**SSD-23700028: Response to Submissions (RtS) Tallawang Solar Farm - Castlereagh Highway (HW18), Tallawang**

TNSW has reviewed Transport Impact Assessment (TIA) prepared by Aurecon, dated 9 April 2024, Reference P521009, Revision D and requests updates to the project's traffic transport impacts on the State road network. Details of the requested additional required are set out in **Attachment 1** and **Attachment 2**.

### **SSD-23700028 Response to Submissions (RtS) - Tallawang Solar Farm, Castlereagh Highway (HW18), Tallawang**

PROJECT	TALLAWANG SOLAR FARM
TITLE	EXTERNAL INTERSECTIONS CASTLEREAGH HIGHWAY / SOLAR FARM ACCESS INTERSECTION PLAN - CHR / AUL
DRAWING No.	20-010-INT3-4
REV	E

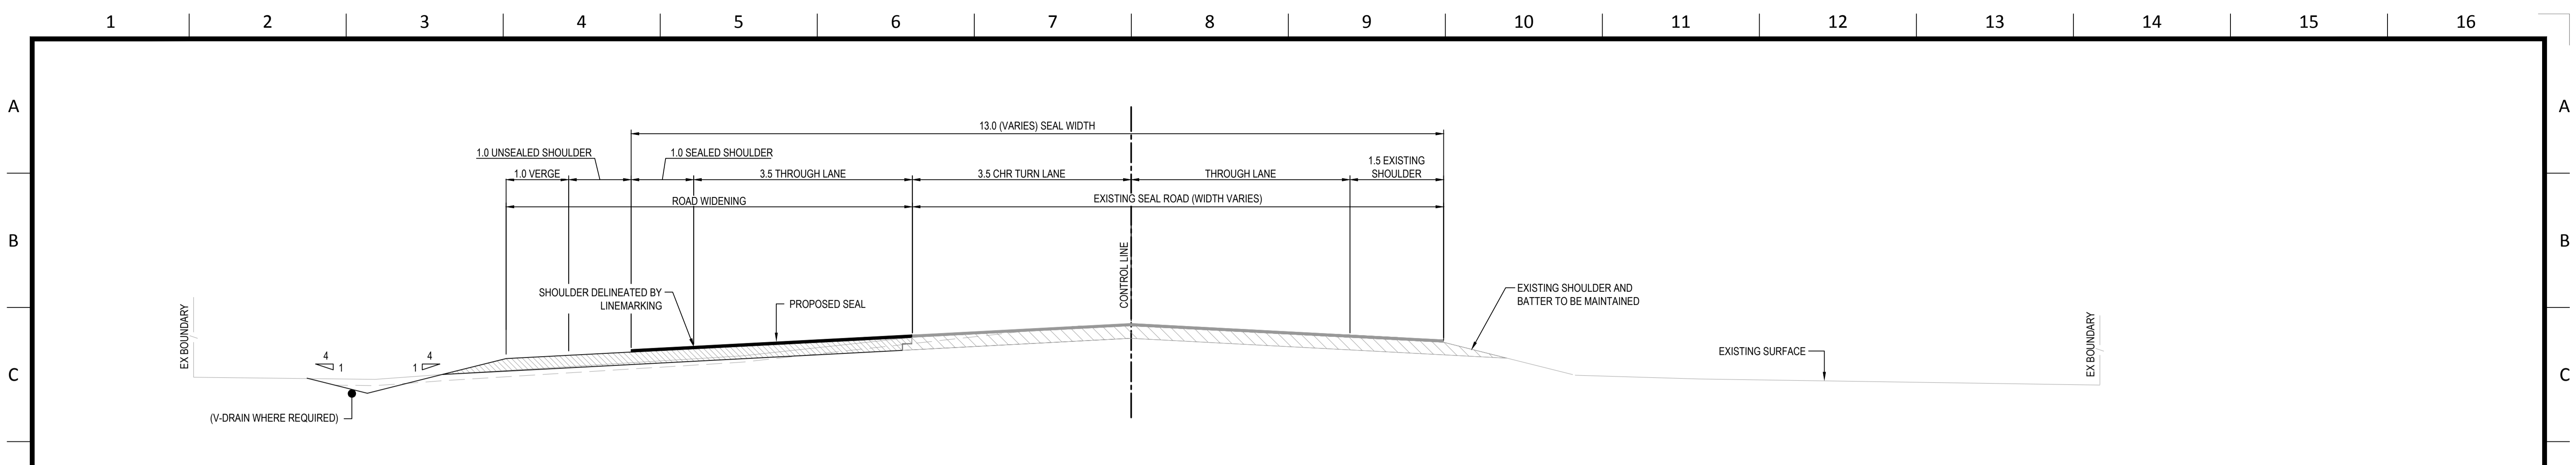
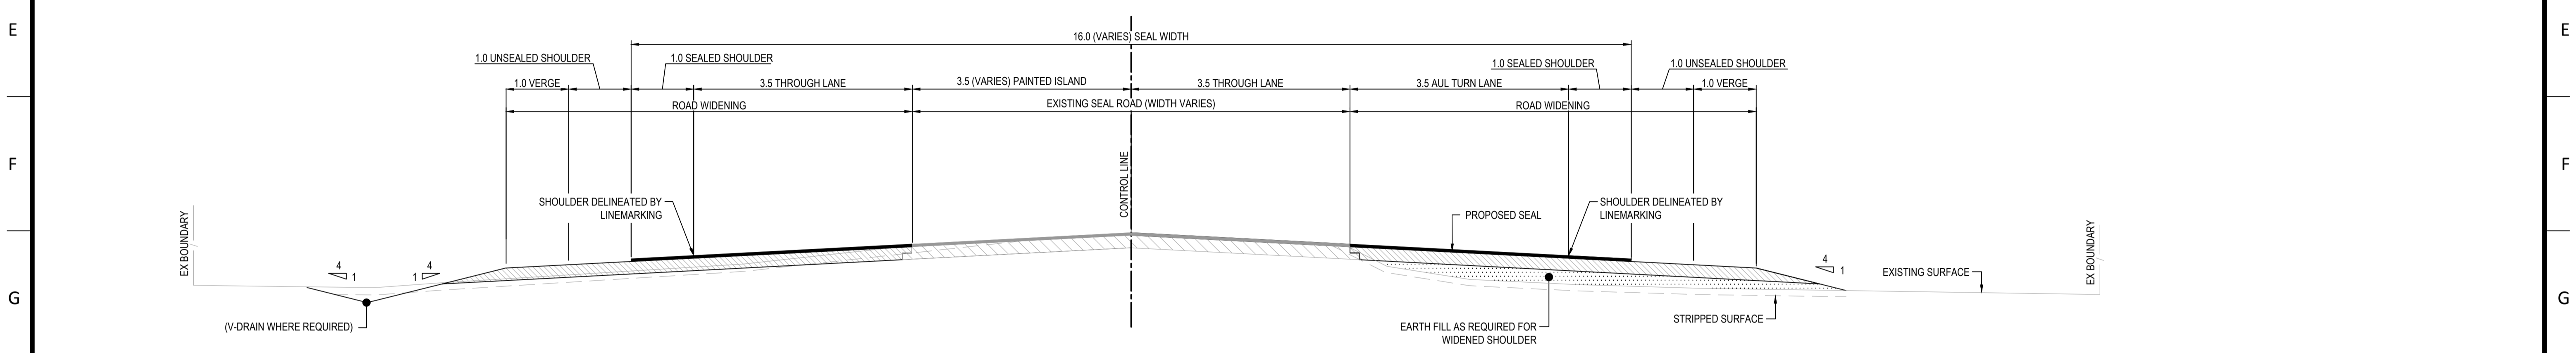
1. The trailing taper for the AUL is required to be measured from the point where the median is 3.5m (refer to figure 1 in Attachment 2). The strategic design must be revised to address this point and ensure the trailing taper is compliant with *Austroads*.

3. The strategic design is to be amended to show the proposed AUL extending past the intersection of Jenkins Lane (refer to figure 2 within Attachment 2) to accommodate the safe turning of entering and exiting the property access onto Castlereagh Highway.

5. The strategic design is to be revised to identify a sealed shoulder for a minimum width of one (1) metre to ensure compliance with *Austroads* and TfNSW requirements.
